STAFF REPORT TUMBLING RIDGE LONG PLAT (LP-23-00002)

Requested Action: Tumbling Ridge LLC & Lucky Load LLC submitted an application for a 7-lot plat on 2 parcels totaling 35.4 acres of land. The proposal includes 7 residential lots ranging in size from 5.01 acres to 5.17 acres. The subject parcels are zoned Rural 5. It is part of a Rural Residential Land Use designation on the south parcel and Mineral Land Use designation on the north parcel.

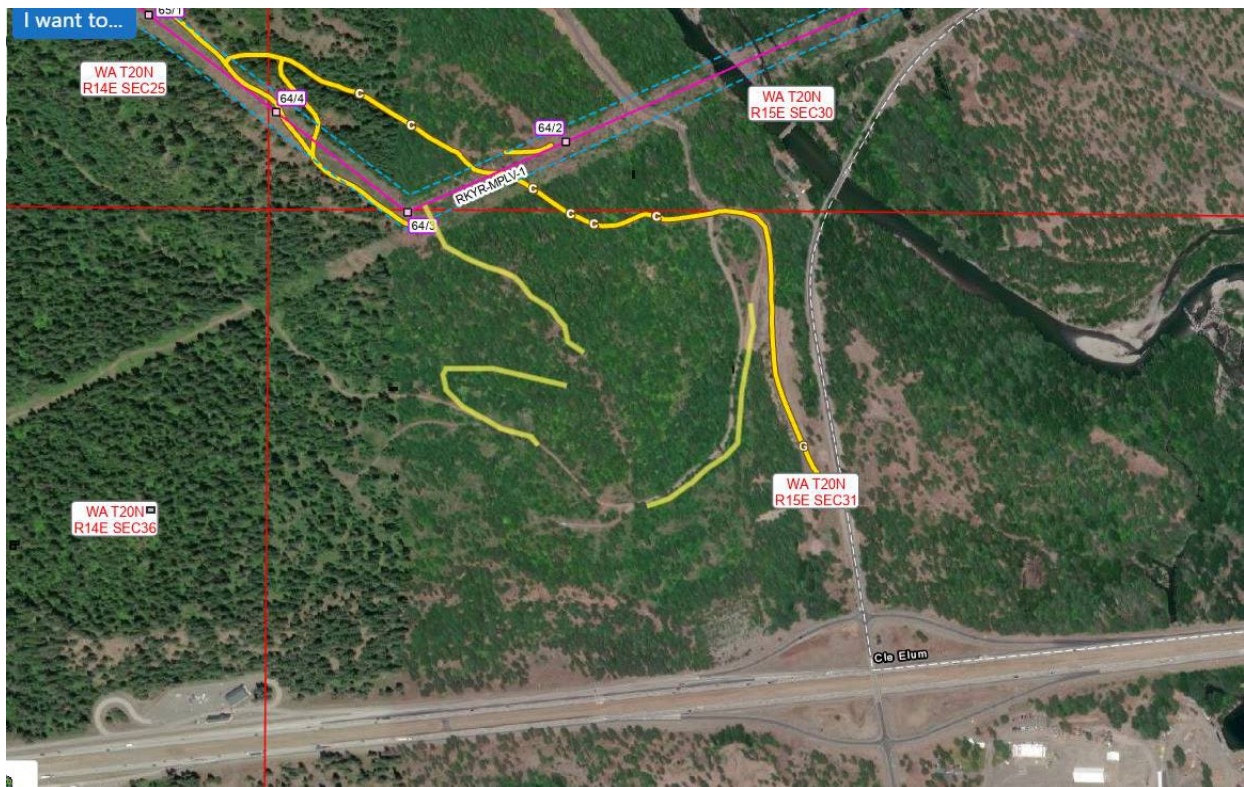
Bonneville Power Administration (BPA): BPA commented that the project appears to impact BPA’s access roads and access right-of-way. BPA’s rights need to be reserved for BPA’s uses. They mentioned that if any of the applicant’s uses will impact BPA’s access road or other access rights, they will need to reach out and work with BPA to retain BPA’s access rights and establish routes of travel prior to any work or development taking place.

Applicant Response: “No impacts to BPA access are anticipated. All existing access points will continue to be in place.”

Staff response: Staff has recommended conditions that all BPA access roads and rights of way be shown on the face of the final plat. Staff has also recommended a condition that BPA give written approval prior to final plat approval that their access ways are not affected by this plat.
